Cottam Solar Project

Statement of Common Ground with Upper Witham Internal Drainage Board [Revision A](#)

PINS Ref: EN010133

Document reference: ~~EX1EX4~~/C8.3.7 [_A](#)

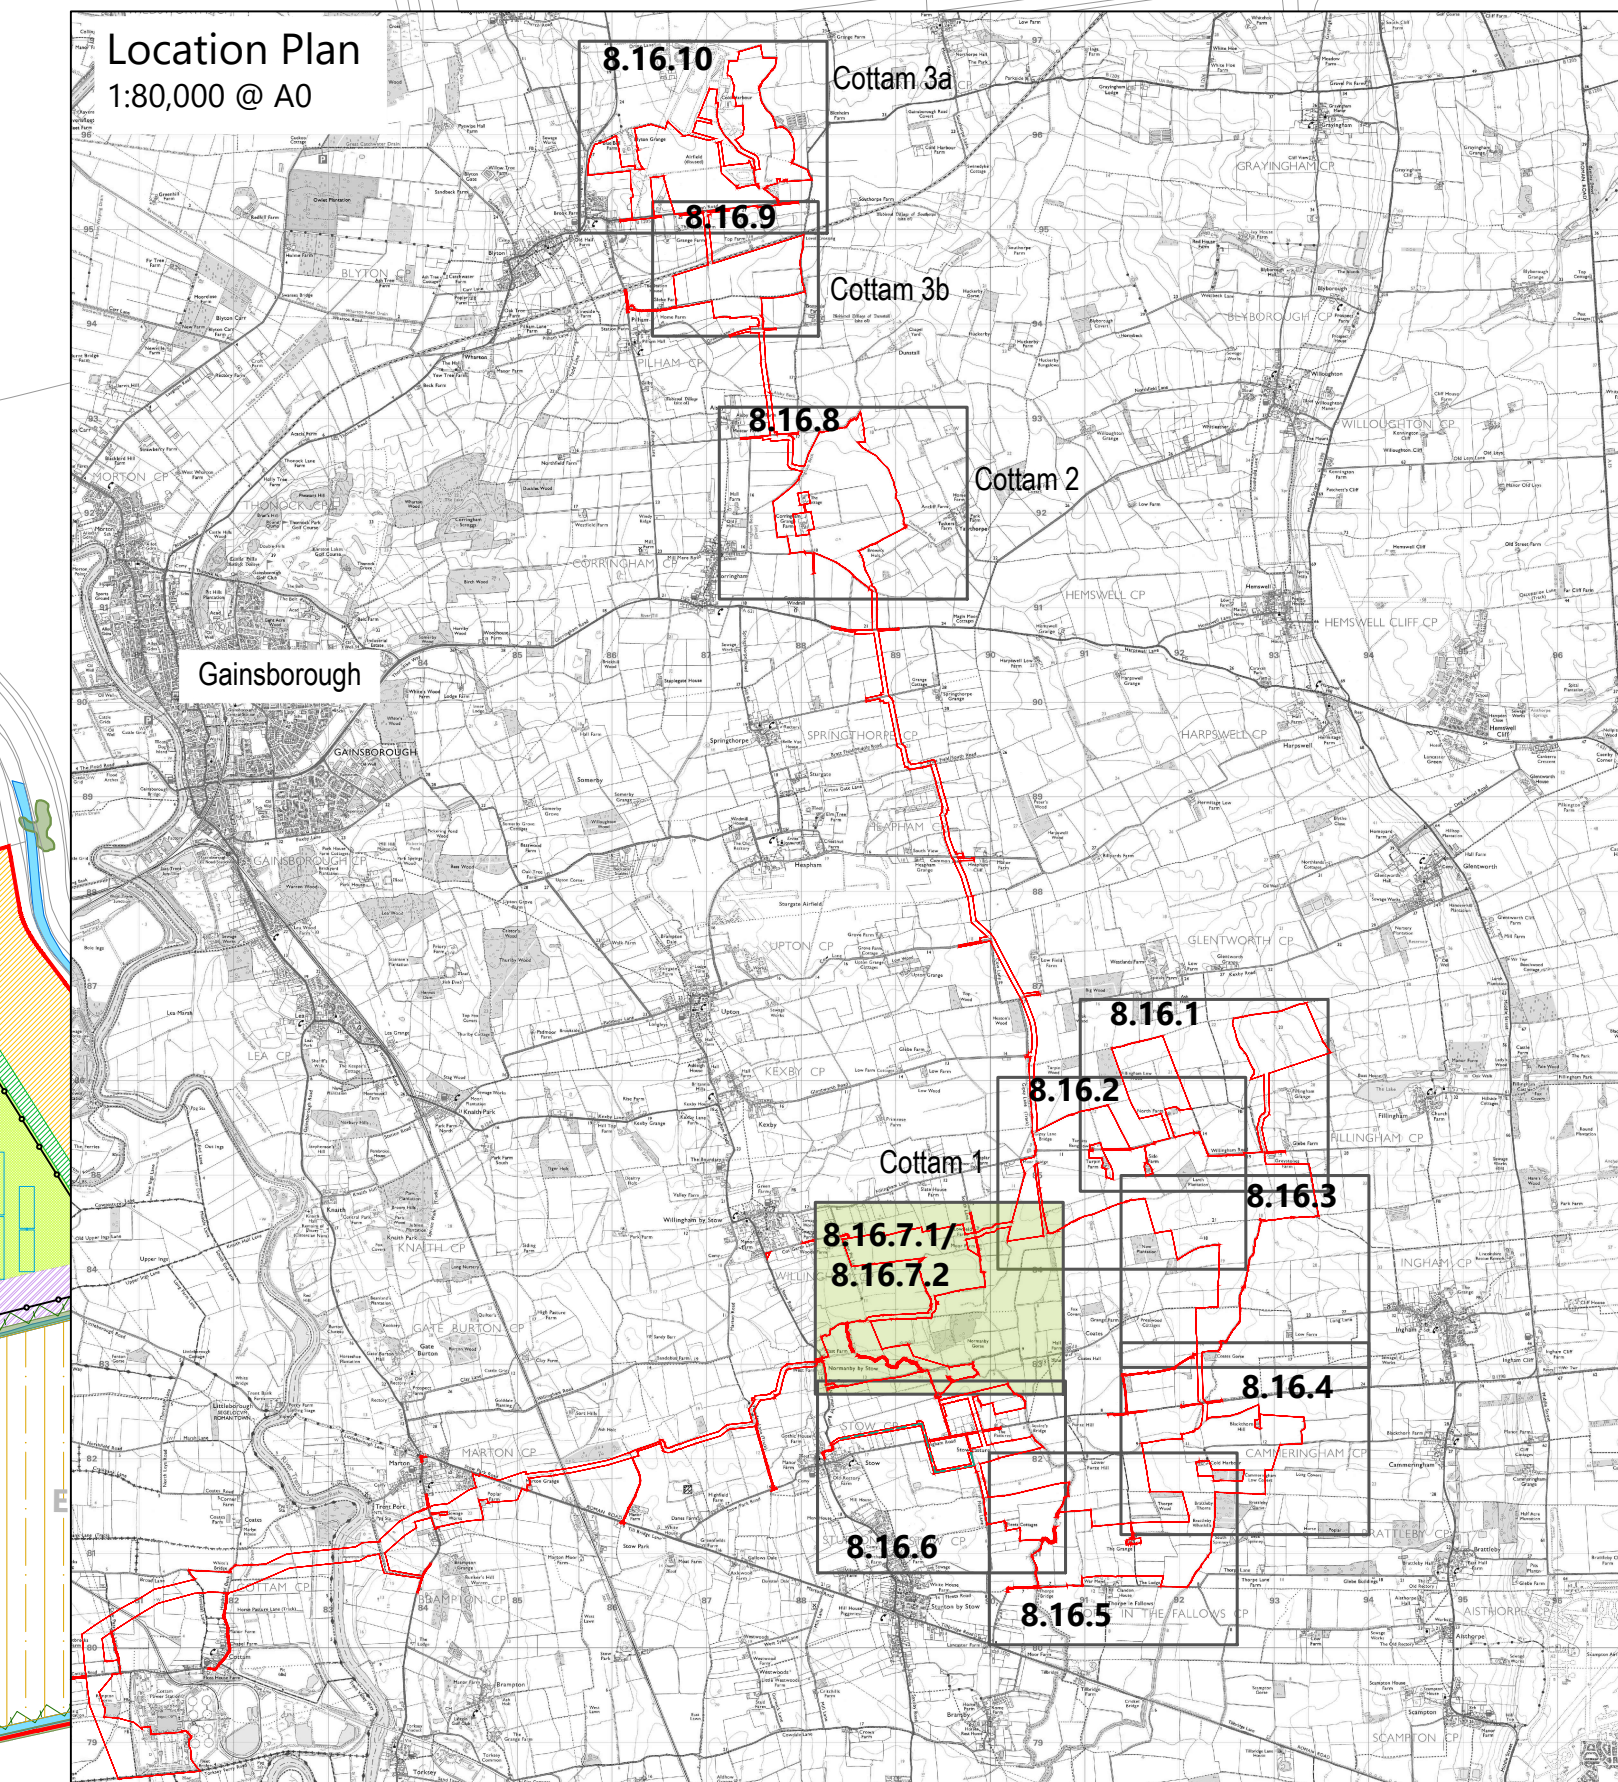
<ul style="list-style-type: none"> • IDB watercourses not clearly identified. <p>0700 - Cricket Till o Fencing and potentially solar panels within the 9m Byelaw distance (from the top of the bank) preventing access for maintenance Figure 8.16.7.1 & 2</p> <p>IDB watercourses not clearly identified. • 0500 - East Till o Fencing, planting and potentially solar panels within the 9m Byelaw distance (from the top of the bank) preventing access for maintenance</p> <p>0400 - Padmoor Drain o No comments</p> <p>0106 - Throops Drain o Fencing, planting and potentially solar panels within the 9m Byelaw distance (from the top of the bank) preventing access for maintenance Figure 8.16.6</p> <ul style="list-style-type: none"> • IDB watercourses not clearly identified. <p>0106 - Throops Drain o Fencing, planting and potentially solar panels within the 9m Byelaw distance (from the top of the bank) preventing access for maintenance Only Cottam 1 is within the area relevant to Upper Witham IDB. For Cottam 2 and Cottam 3A/3B Scunthorpe & Gainsborough IDB should be consulted.</p>

### Figure 8.16.2: Landscape and Ecology Mitigation and Enhancement Plan – Cottam 1 North (Sheet 2) Revision A

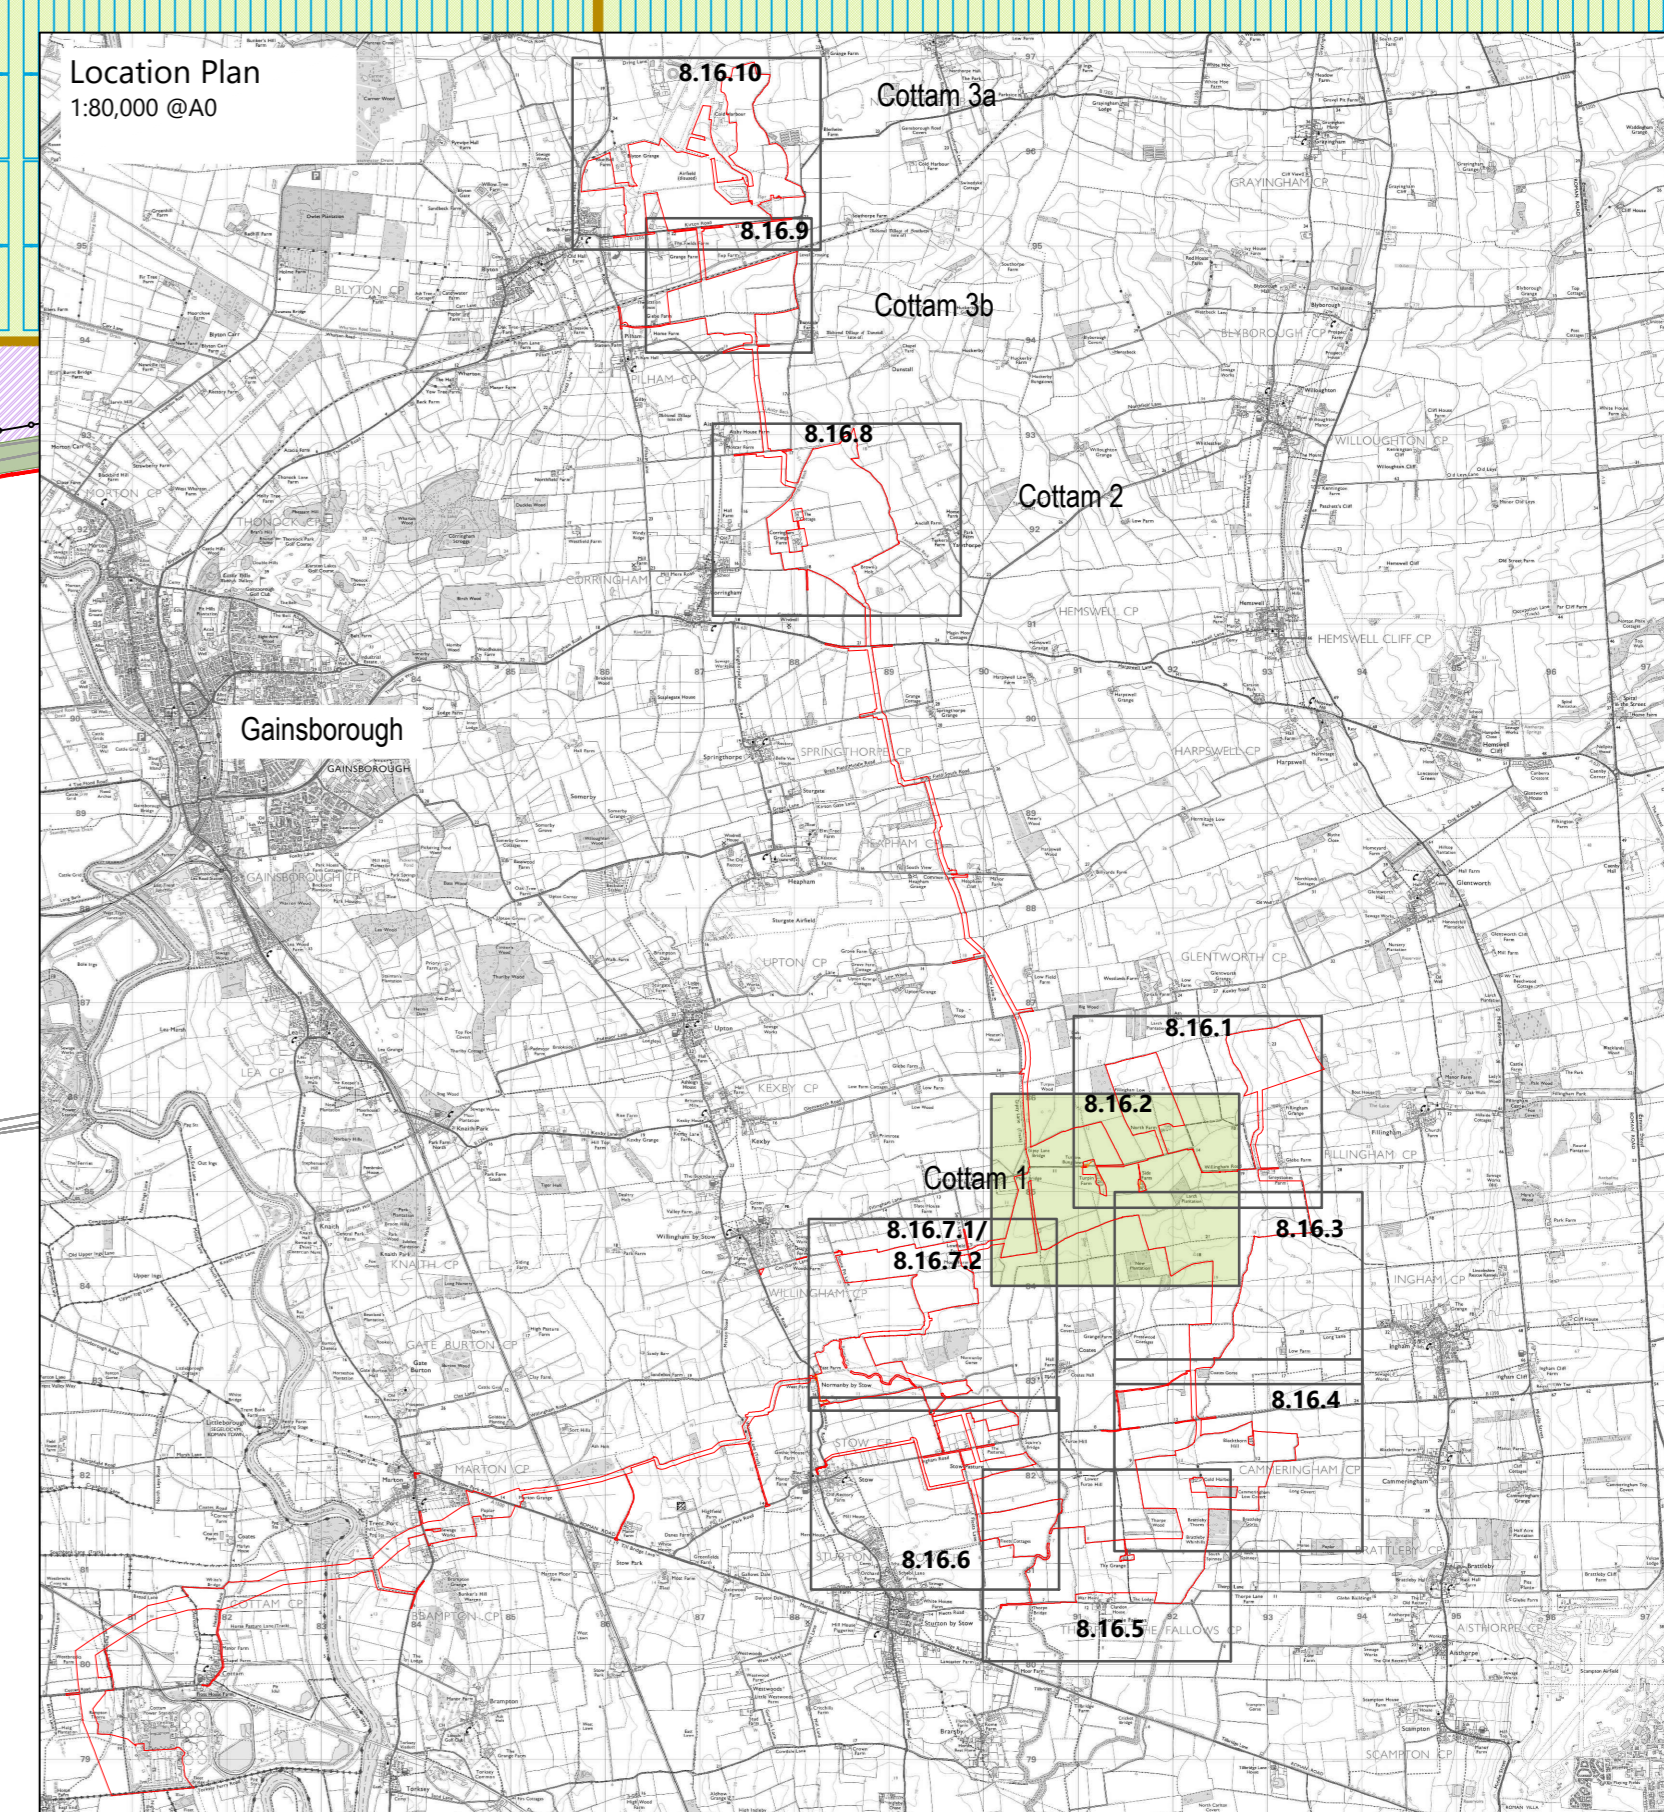
<p><u>Hydrology</u></p> <p><u>HY-03</u></p>	<p>Identification of Watercourses</p>	<p><i>“Figure 8.16.2: IDB watercourses not clearly identified.</i></p> <p><i>0502 - Fillingham South Drain. Fencing, planting and potentially solar panels within the 9m Byelaw distance (from the top of the bank) preventing access for maintenance</i></p> <p><i>0500 - East Till. Fencing, planting and potentially solar panels within the 9m Byelaw distance (from the top of the bank) preventing access for maintenance.</i></p> <p><i>Figure 8.16.3: IDB watercourses not clearly identified.</i></p> <p><i>0600 - Cammeringham Drain. Fencing, planting and potentially solar panels within the 9m Byelaw distance (from the top of the bank) preventing access for maintenance.</i></p> <p><i>Figure 8.16.4: IDB watercourses not clearly identified.</i></p> <p><i>0600 - Cammeringham Drain. Fencing, planting and potentially solar panels within the 9m Byelaw distance (from the top of the bank) preventing access for maintenance.</i></p> <p><i>Figure 8.16.5: IDB watercourses not clearly identified.</i></p> <p><i>0700 - Cricket Till. Fencing and potentially solar panels within the 9m Byelaw distance (from the top of the bank) preventing access for maintenance.</i></p> <p><i>Figures 8.16.7.1 & 2: IDB watercourses not clearly identified.</i></p> <p><i>0500 - East Till. Fencing, planting and potentially solar panels within the 9m Byelaw distance (from the top of the bank) preventing access for maintenance.</i></p>	<p>These IDB watercourses and drains have been considered throughout the layouts with a 9m offset as has been possible and as shown on Landscape and Ecology Mitigation and Enhancement Plans (Figures 8.16.1 to 8.16.10) [APP-305 to APP-315]. The Applicant has discussed this matter with the IDB and both parties are in agreement that the scale of the Scheme makes it impossible to provide the full information regarding detailed design at this stage.</p> <p>The Applicant notes that the drawings are based on the currently available data and mapping and in some cases the ‘top of bank’ is not defined. It notes that further survey work will be required to establish the ‘top of bank’ which will in turn give the 9m offset and required clear working access. The IDB can provide a shape file to confirm the locations during the detailed design stage post DCO consent.</p> <p>The Applicant will then provide a specific plan to the IDB at the detailed design stage (post DCO consent) to give clear details of all 9m offsets to the IDB’s maintained watercourses and drains.</p>

Figure 8.16.5: Landscape and Ecology Mitigation and Enhancement Plan – Cottam 1 South (Sheet 2) Revision A

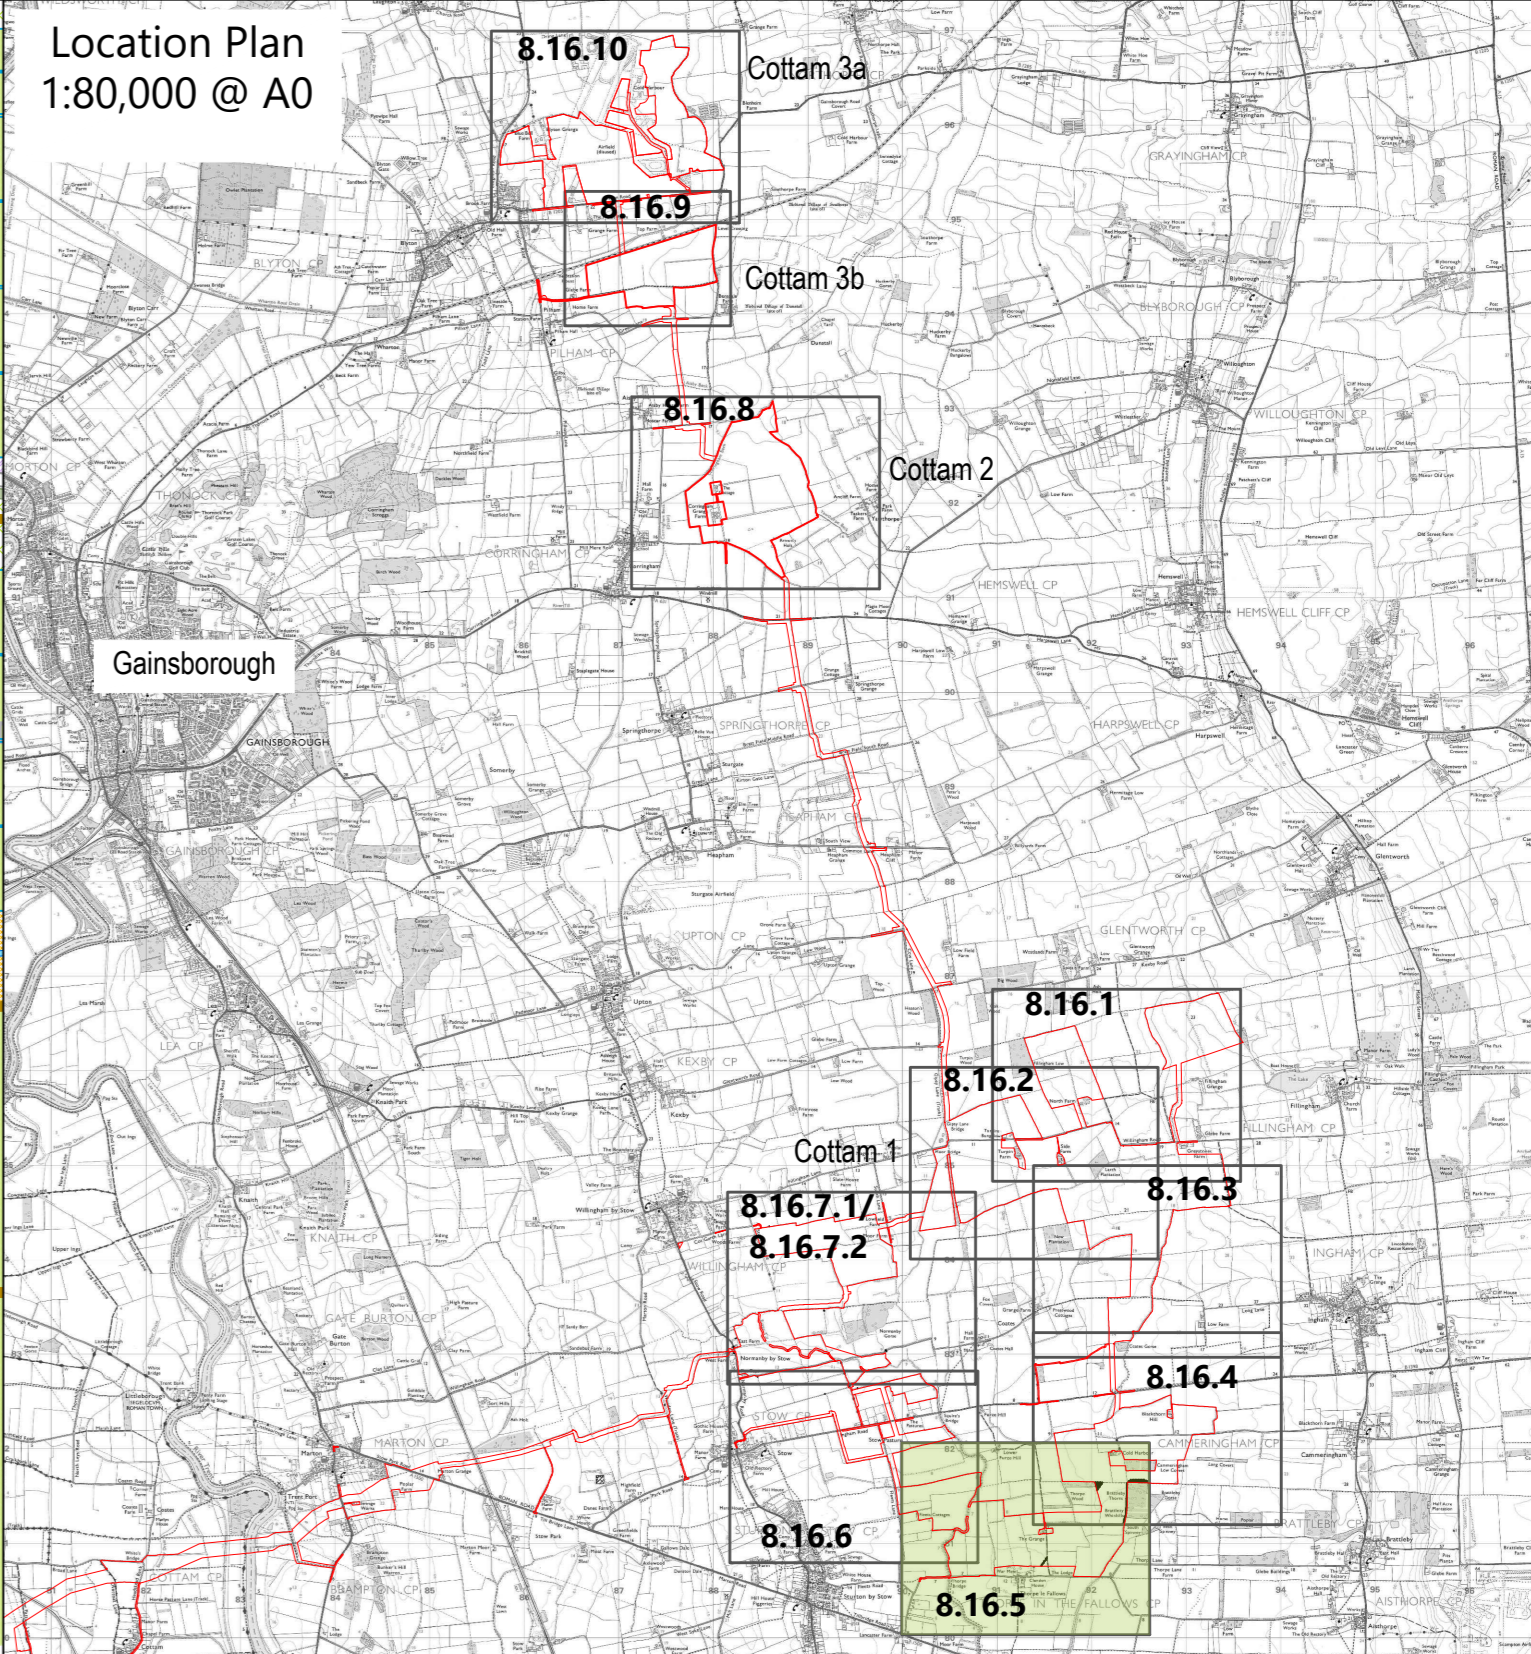
<p>Zones 2 and 3 on the basis of the additional flood protection offered by their potential to be stowed horizontally.'</p> <ul style="list-style-type: none"> • It is noted 'Electrical infrastructure associated with the panels can be adequately waterproofed to withstand the effect of flooding. Where possible the sensitive electrical equipment has been located in parts of the Site that are within Flood Zone 1. Where this hasn't been possible, equipment will be raised 0.6 m above the 0.1% Annual Exceedance Probability (AEP) flood level or where this is not possible as high as practicable.' EN010133-000461-C7.6 Design and Access Statement_Part 2 of 4 Solar Panels and fencing within 9m of the top of the bank of an Upper Witham IDB watercourse. <p>EN010133-000462-C7.6 Design and Access Statement_Part 3 of 4 Figure 8.16.2</p> <ul style="list-style-type: none"> • IDB watercourses not clearly identified. <p>0502 - Fillingham South Drain o Fencing, planting and potentially solar panels within the 9m Byelaw distance (from the top of the bank) preventing access for maintenance</p> <p>0500 - East Till o Fencing, planting and potentially solar panels within the 9m Byelaw distance (from the top of the bank) preventing access for maintenance Figure 8.16.3</p> <ul style="list-style-type: none"> • IDB watercourses not clearly identified. <p>0600 - Cammeringham Drain o Fencing, planting and potentially solar panels within the 9m Byelaw distance (from the top of the bank) preventing access for maintenance Figure 8.16.4</p> <ul style="list-style-type: none"> • IDB watercourses not clearly identified. <p>0600 - Cammeringham Drain o Fencing, planting and potentially solar panels within the 9m Byelaw distance (from the top of the bank) preventing access for maintenance Figure 8.16.5</p>
